Ecological comments

Planning Application No: 3/2011/1071

Proposals: Full planning permission for access, landscaping and the erection of 52 new build properties, the conversion of the former barn and refurbishment of existing residential unit.

Location: Land at Chapel Hill, Longridge

Drawing title:
Site Layout Plan as Proposed
Affordable Units

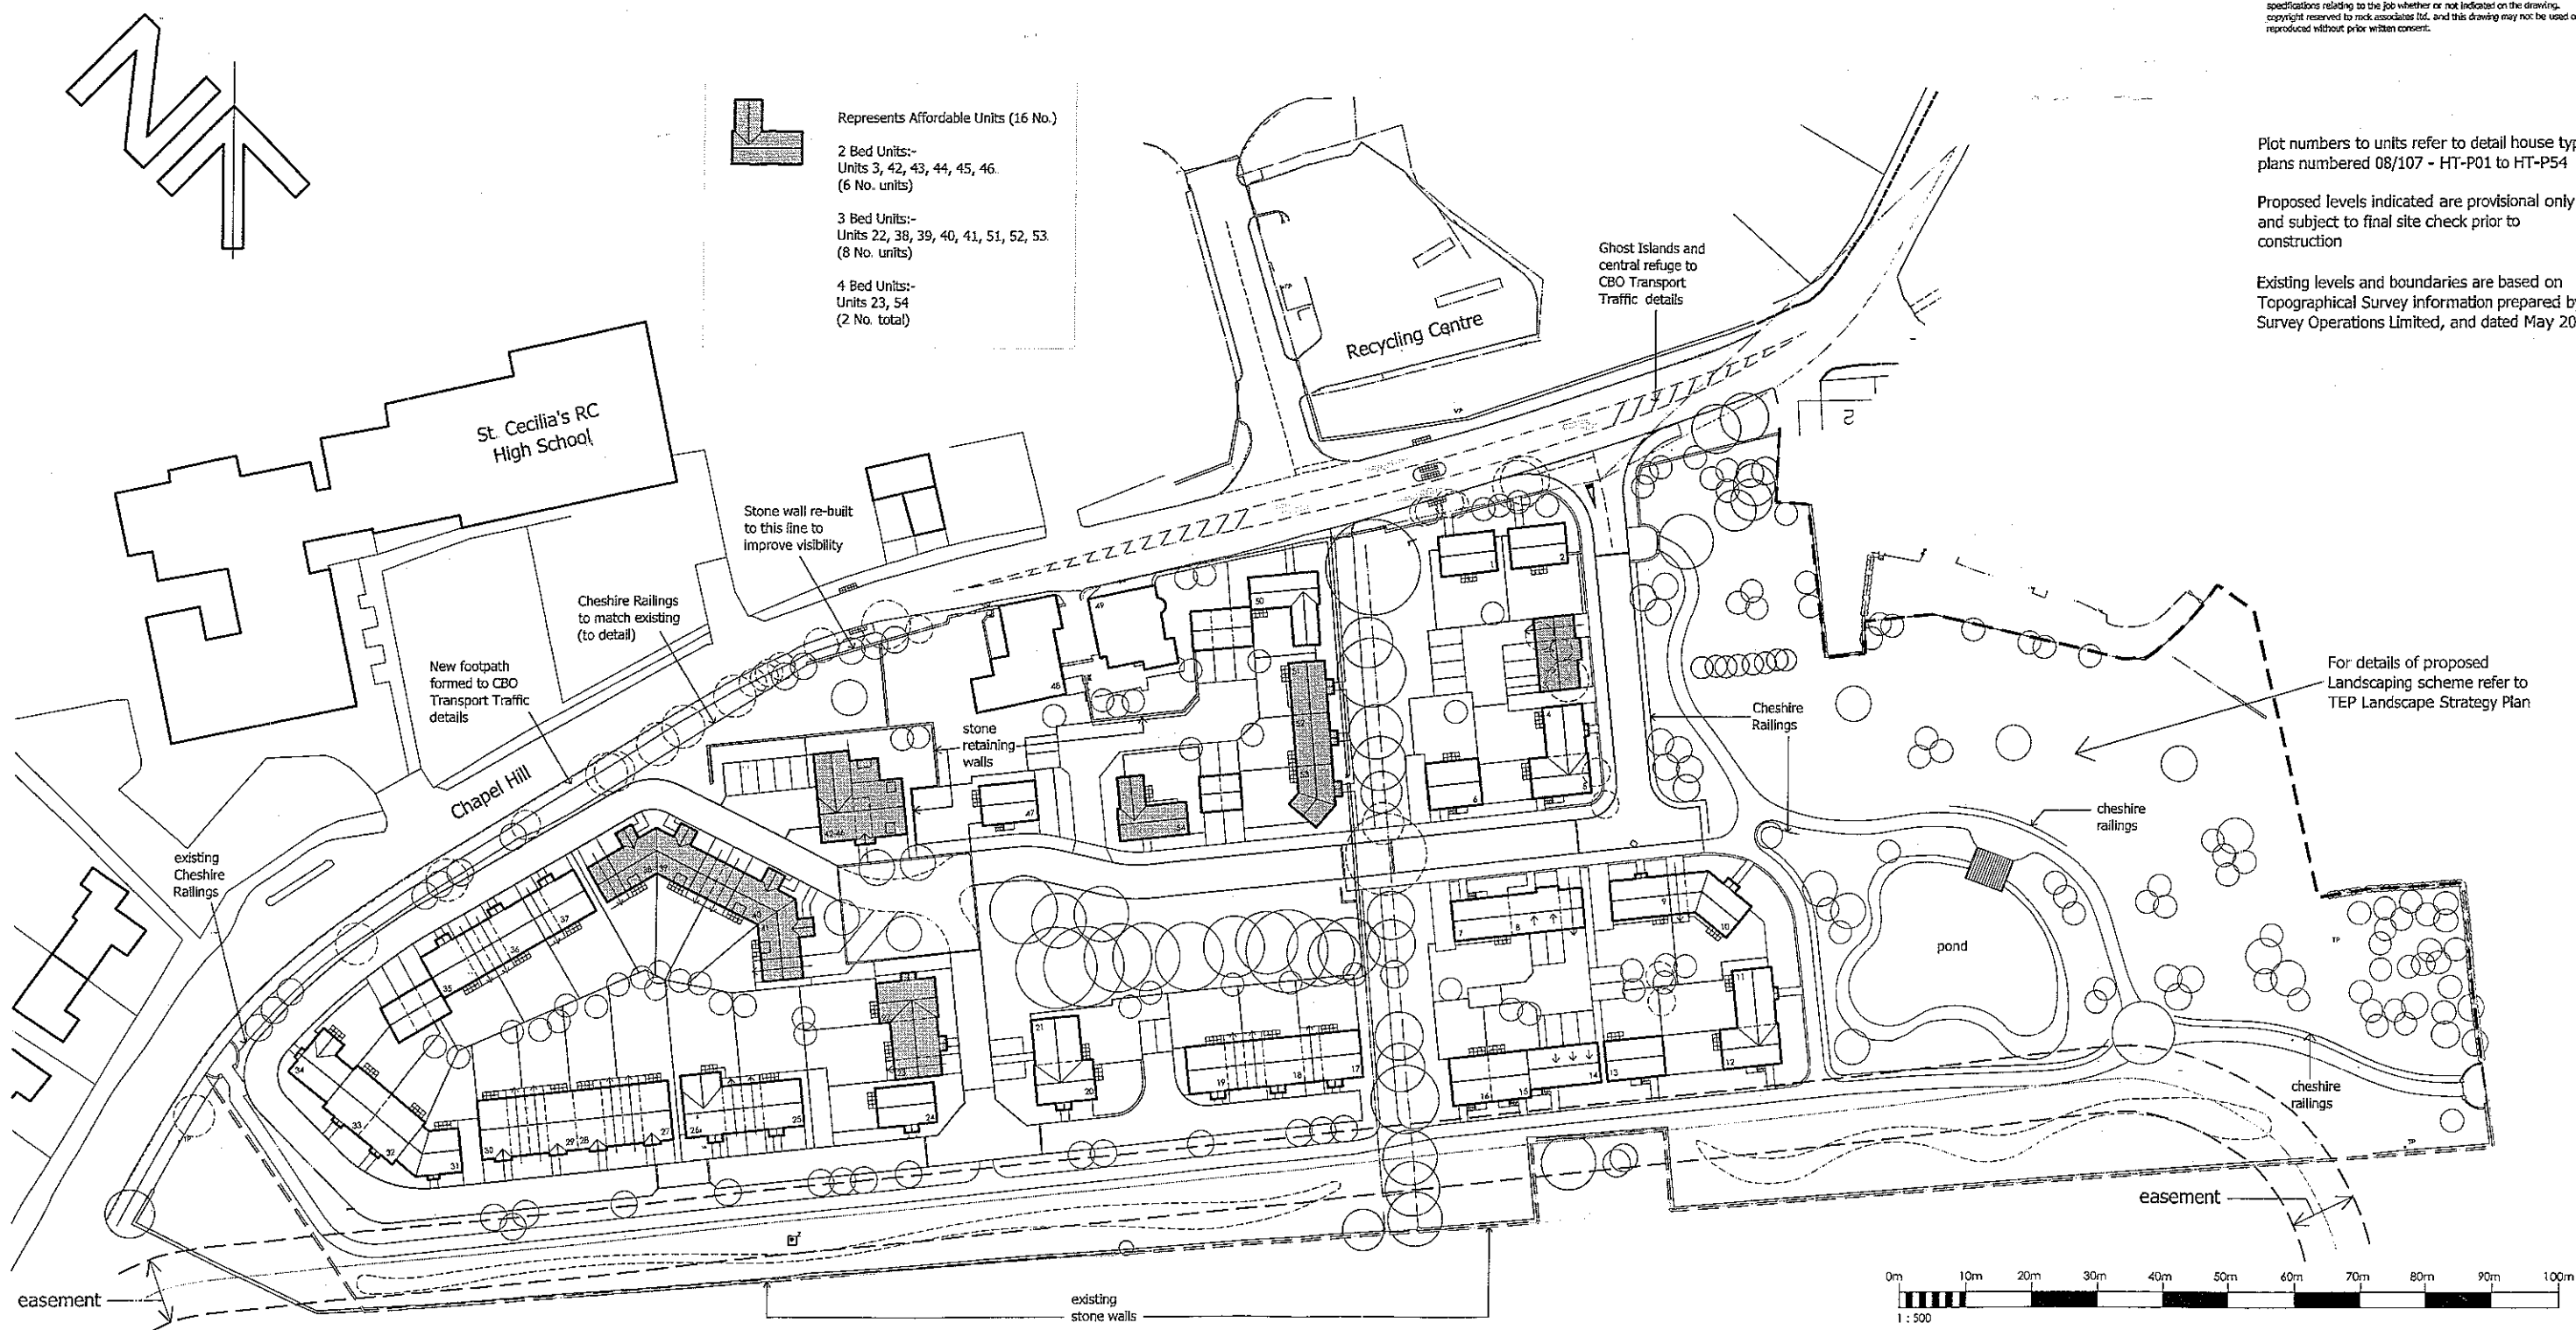
- The proposed "buffer zone" along the southern boundary of the site includes a footpath. It therefore does not function as a buffer zone to protect the BHS from disturbance. Indeed, the footpath will act to bring people and dogs closer to the BHS and may actually increase the likelihood of disturbance. The northern edge of the water appears to be only approximately 20m from the southern edge of the proposed development, and approximately only 30m from the proposed footpath. Without an assessment of how the birds using the reservoir respond to disturbance, it is not clear if the birds would be affected by noise disturbance at this distance (assuming the southern boundary stone wall and proposed hedgerow does act as a visual screen). In addition, the siting of benches along the footpaths and public open space

next to the reservoir will encourage people and dogs to linger, and therefore may result in further increased disturbance to birds using the BHS.

- The above policies require maintenance and enhancement of habitat connectivity. The proposed pond is isolated from semi-natural habitat being surrounded by footpaths. In order to ensure ease of movement for species such as amphibians it is recommended that the pond link into semi-natural habitat on at least one side.

- The siting of scattered trees across the proposed species-rich grassland will reduce the area of species-rich grassland, due to shading from the trees and leaf fall, and will make appropriate management of the grassland difficult. It is recommended that new trees are sited on the areas of amenity grassland, to the northern edge of the species-rich grassland or close to existing trees.

- The siting of species rich grassland surrounding the swales is also likely to make appropriate management difficult. In addition, given they may be used by amphibians, it may be more appropriate to have more suitable habitat for amphibians between the swales and the proposed hedgerow along the southern boundary, such as rough grassland, with species rich grassland between the swales and the footpath.
